Rezoning Transportation Analysis

Petition Number: 2021-104

Date	Description
08-20-2021	First Review (KP)

Table with columns: FILE NUMBER: 8085-02, DATE: 04/12/2021, REZONING PETITION #2021-104 SCHEMATIC SITE PLAN, BEECHWOOD JACKSON, LLC, FERNCLIFF TOWNHOMES, and other project details.

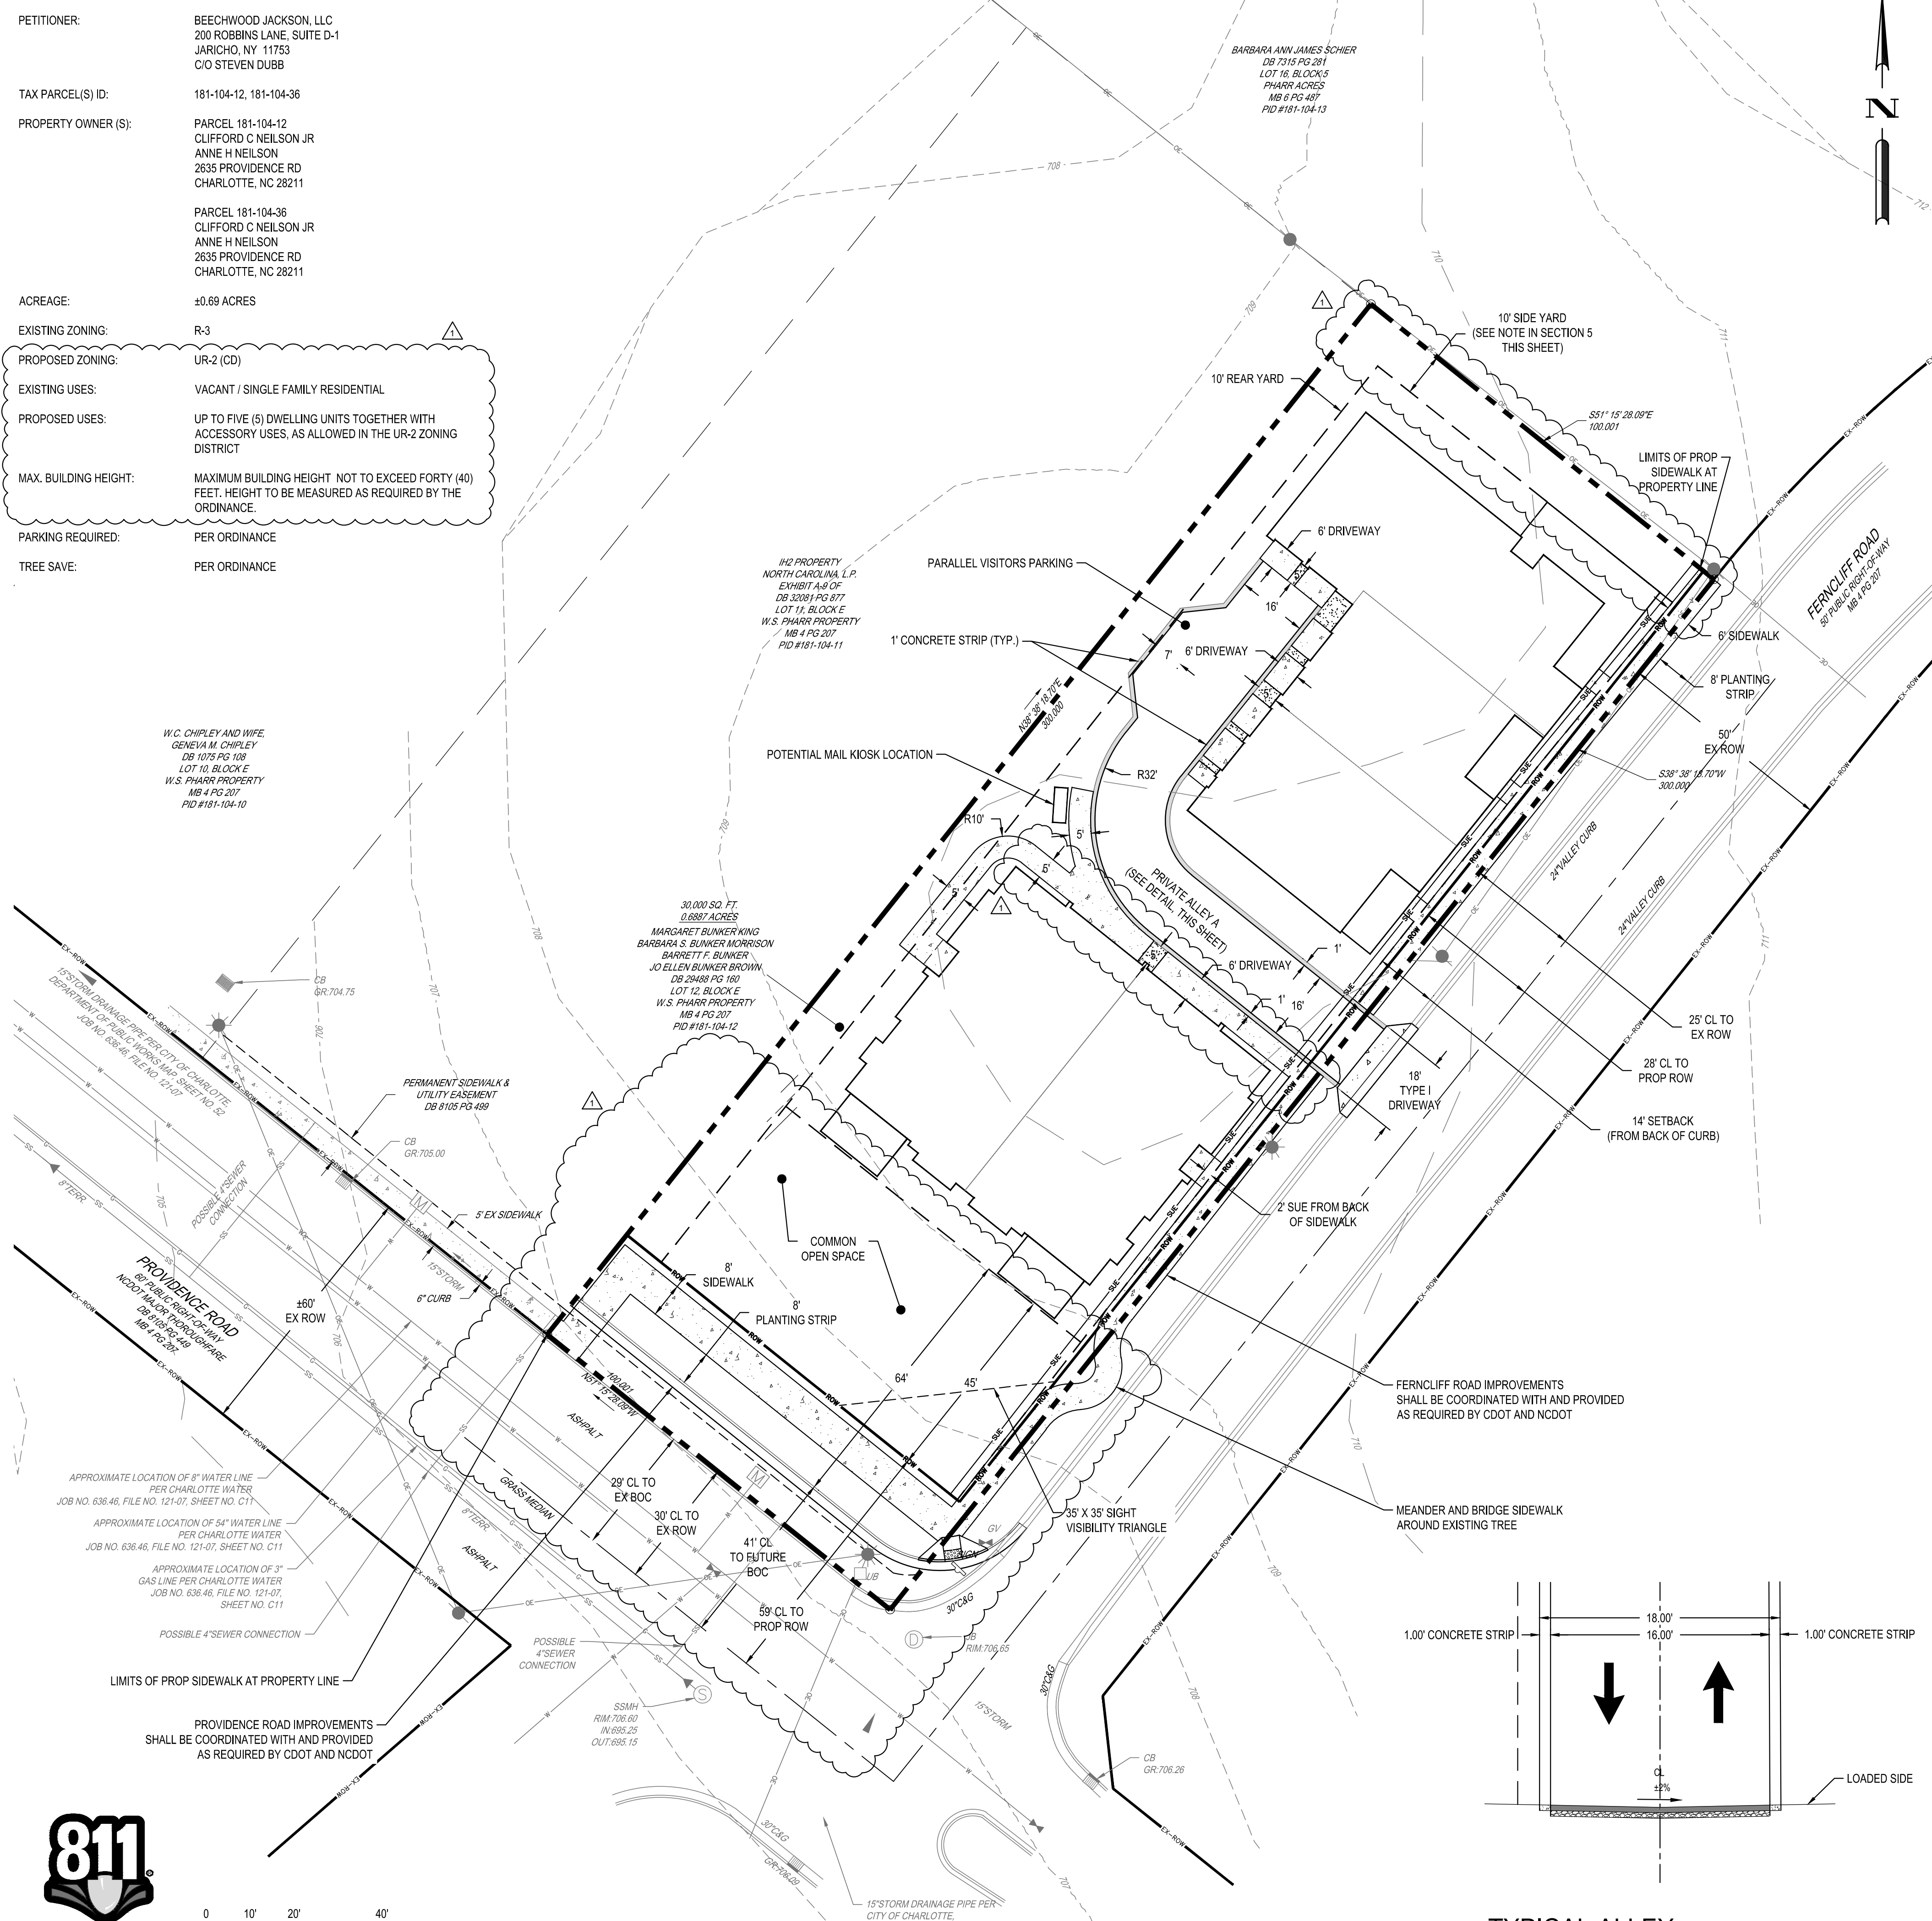
1. **Curb line:** The proposed zoning district has a setback measured from back of the existing or proposed future curbline.
 - a. **Ferncliff Road:** Location of curb and gutter may remain in it's existing location.
 - b. **Providence Road:** The location of the future back of curb will be 41-feet from the existing centerline.

Label and dimension the existing and future back of curb from the centerline for each road on the site plan.

- a. **Ferncliff Road:** Revise site plan and conditional note(s) to commit to dedicate 28-feet of right-of-way from the road centerline
- b. **Providence Road:** Revise site plan and conditional note(s) to commit to dedicate 59-feet of right-of-way from the road centerline.

The site plan shall label and dimension the right-of-way from the existing centerline of each road.

4. Revise the site plan by placing the 8-foot sidewalk, along the site's frontage of Providence Road, relative to the future curb line located 41-feet from the existing centerline of Providence Road.

5. Revise the site plan by realigning the internal private alley(s) to form a T-intersection and construct a street stub at the site's northwest property boundary.

6. Revise the site plan and conditional notes by committing to construct an ADA-compliant curb ramp, to cross Ferncleiff Road, at the corner of Ferncleiff Road and Providence Road.
